**WEST SUSSEX COUNTY COUNCIL
INFRASTRUCTURE CONSULTATION**

SUBJECT: Y/15/11

Longacre Bungalow, Maypole Lane, Yapton

COU from C3 dwelling to D1 nursery

Block Plan 1-200 @ A1

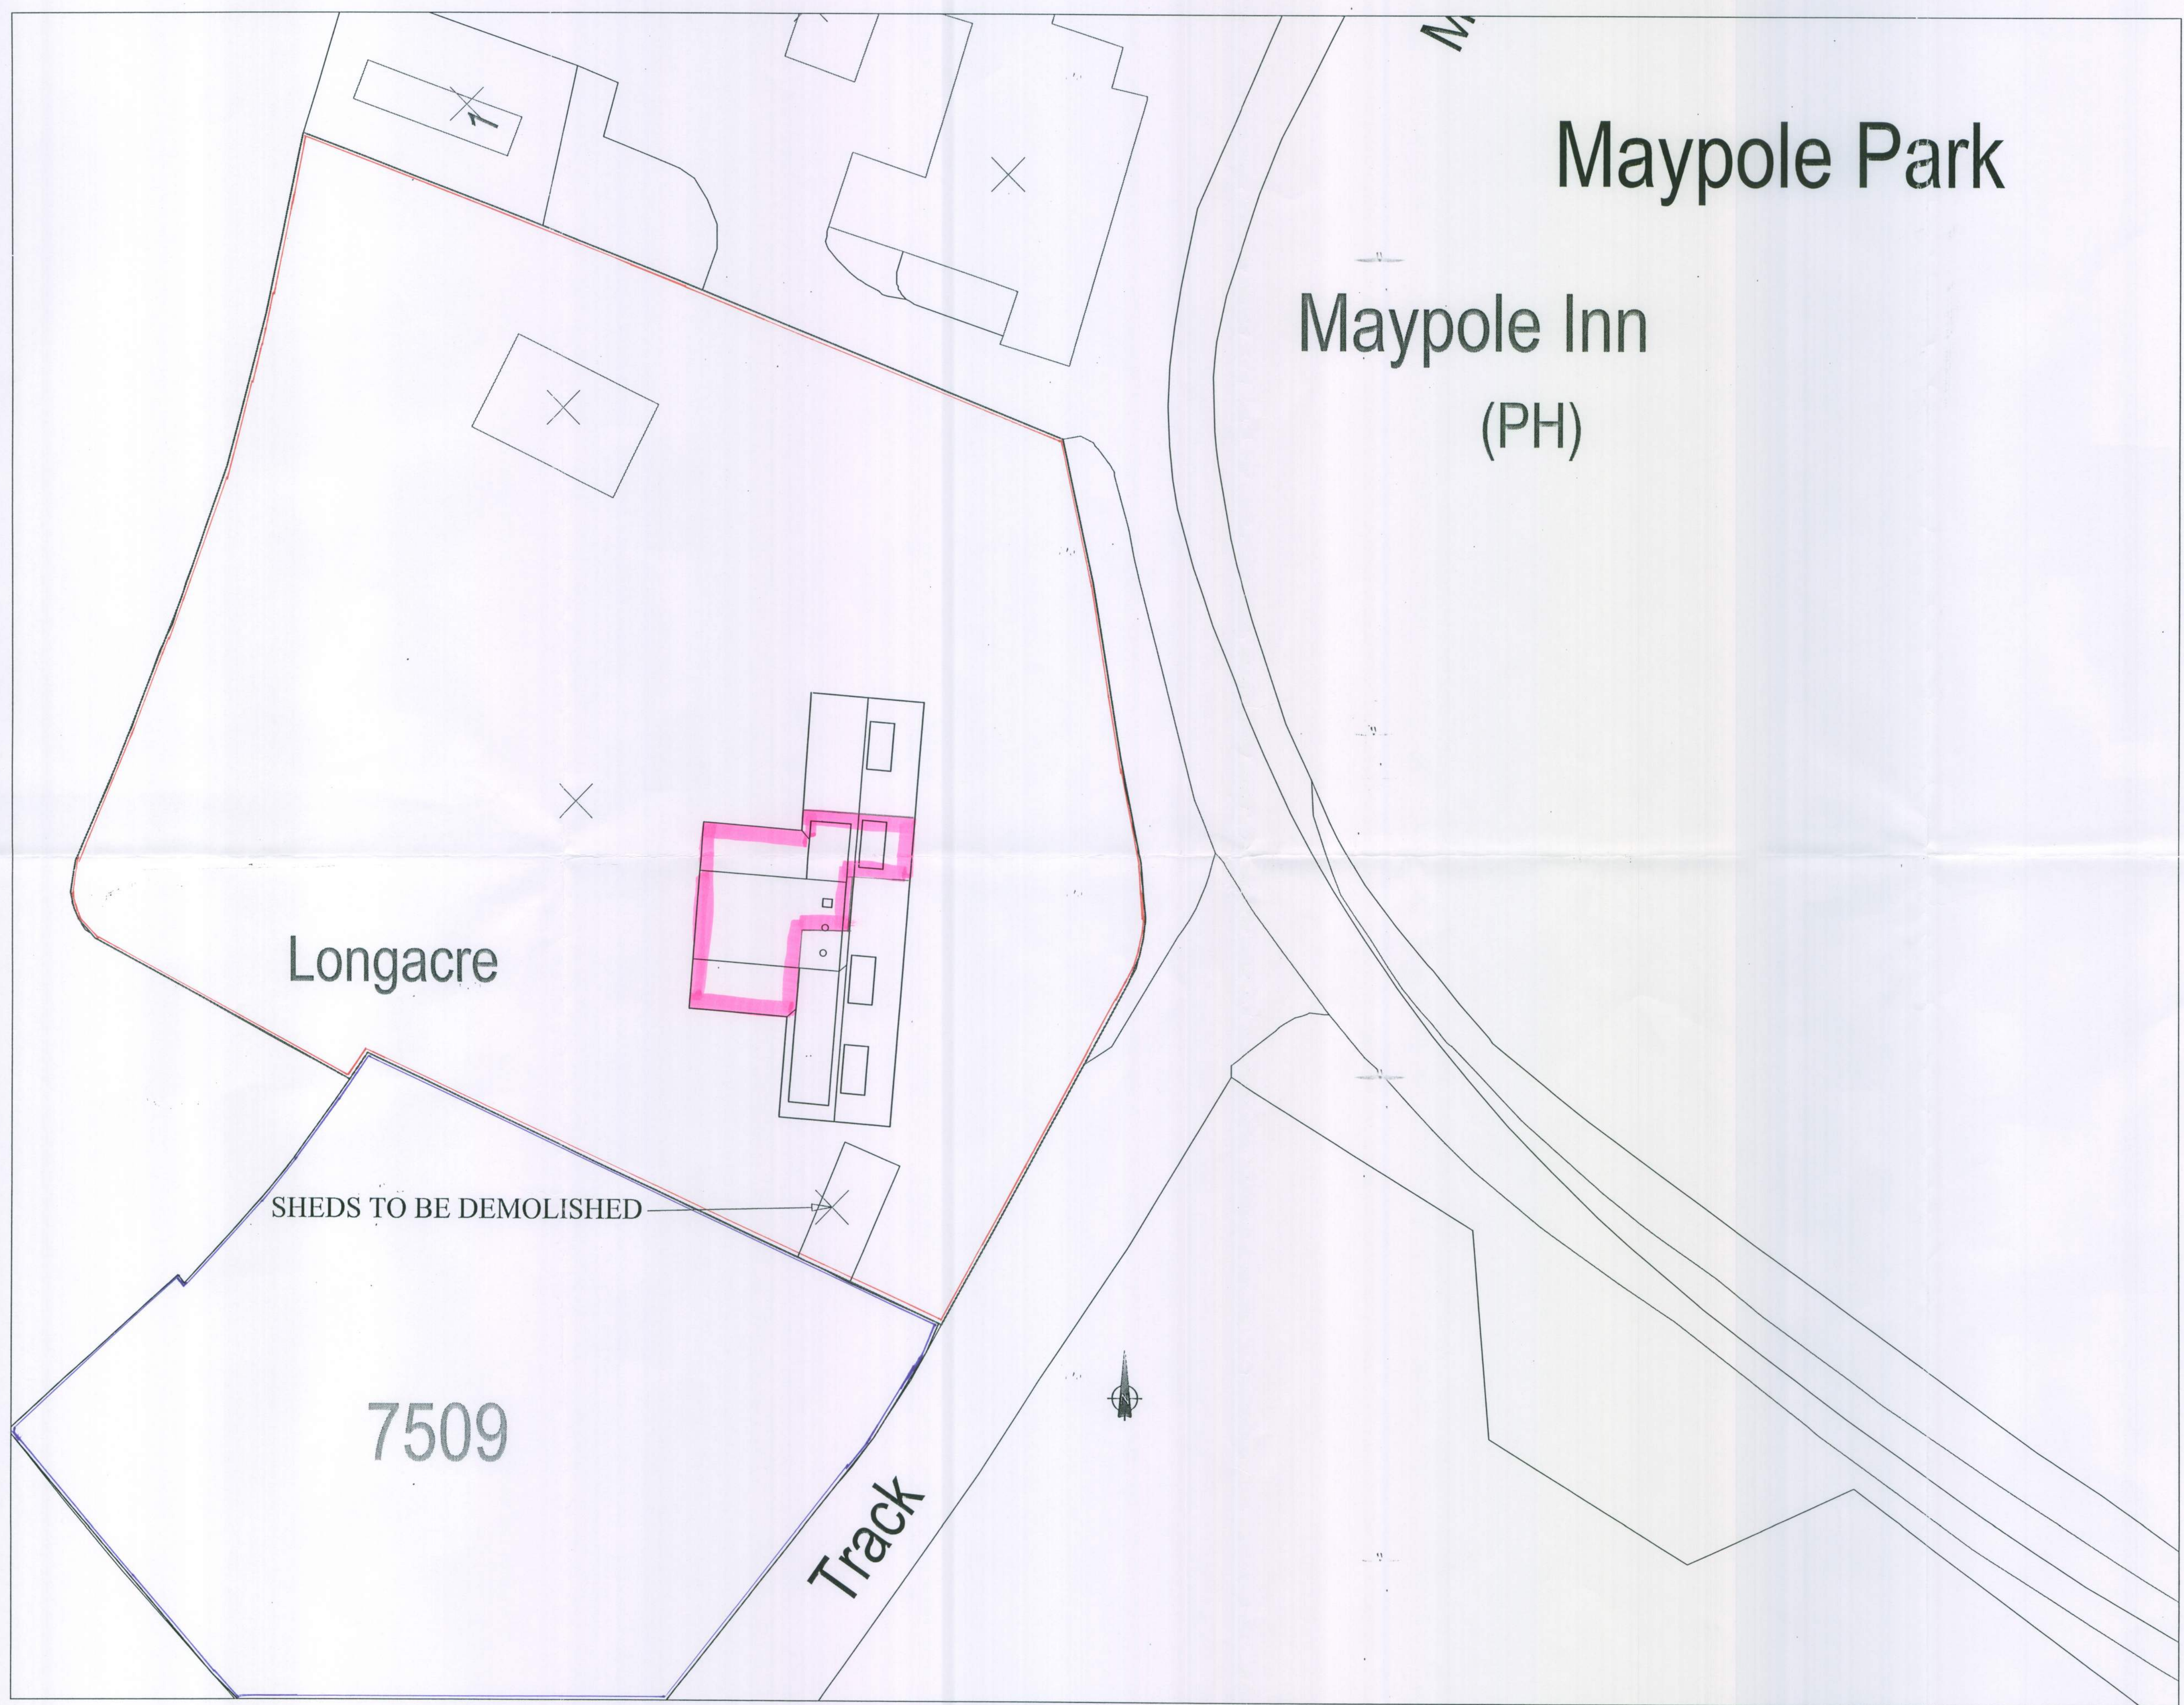
WSCC would request that the Applicant provide more information regarding the location of the proposed parking spaces, and how they will be split between the C3 and D1 uses at the site. Information should also be provided regarding a dedicated turning area, which takes into consideration the movements of children and parents at drop-off and collection times. WSCC would advise the LPA that there can be secured by condition if required.

In summary, WSCC would require the details of parking and turning within the site to be clarified by the Applicant. However, no objections would be raised regarding the principal of the application.
